From
The Member Secretary,
Chennai Metropolitan
Development Authority,
No.1, Gandhi Irwin Road,
CHENNAI -600 008.

Letter No. *Ac/6120/03*

Sub: CMDA - Planning permission - Construction of G.F.F.F
of Residential/~~Commercial~~ Building at *Plot no. 7,*
Ranjith Lane, Kotturpuram in T.S.no. 7/26,
at 7/34, Block no. 14 of Adajgar Village.

SITE PLAN SCALE: 1" = 16' 0" (OR) 1:200

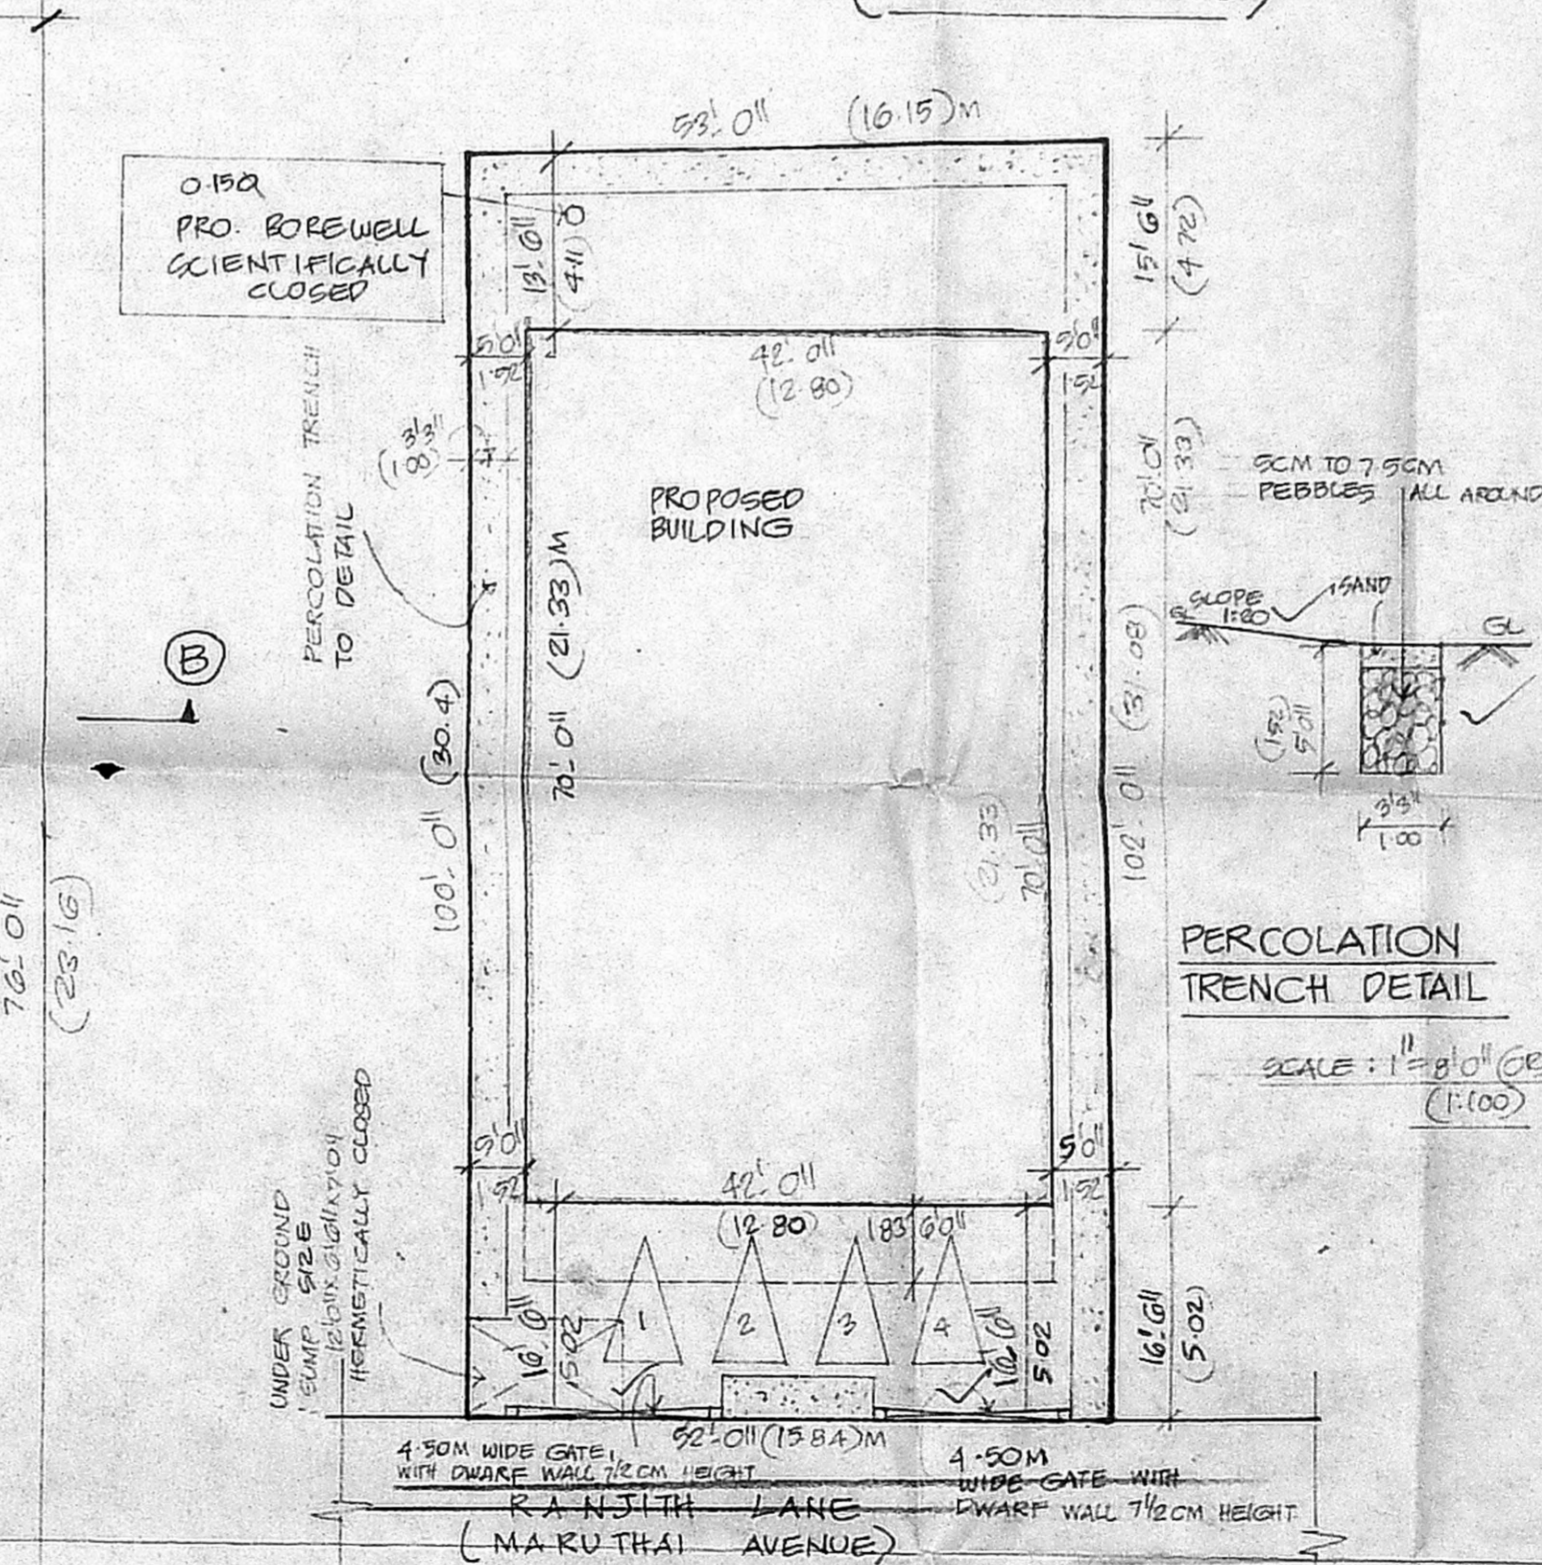
b) Five copies of R.P. rectifying following defects:

- ① ~~Five copies of R.P.~~
- ① Two nos. of 4.50m wide sliding gate for ~~each~~ manovering of 4 nos floors.
- ② Rain ~~water~~ harvest pit sections details to ~~show~~ - as per standard with compound well details.
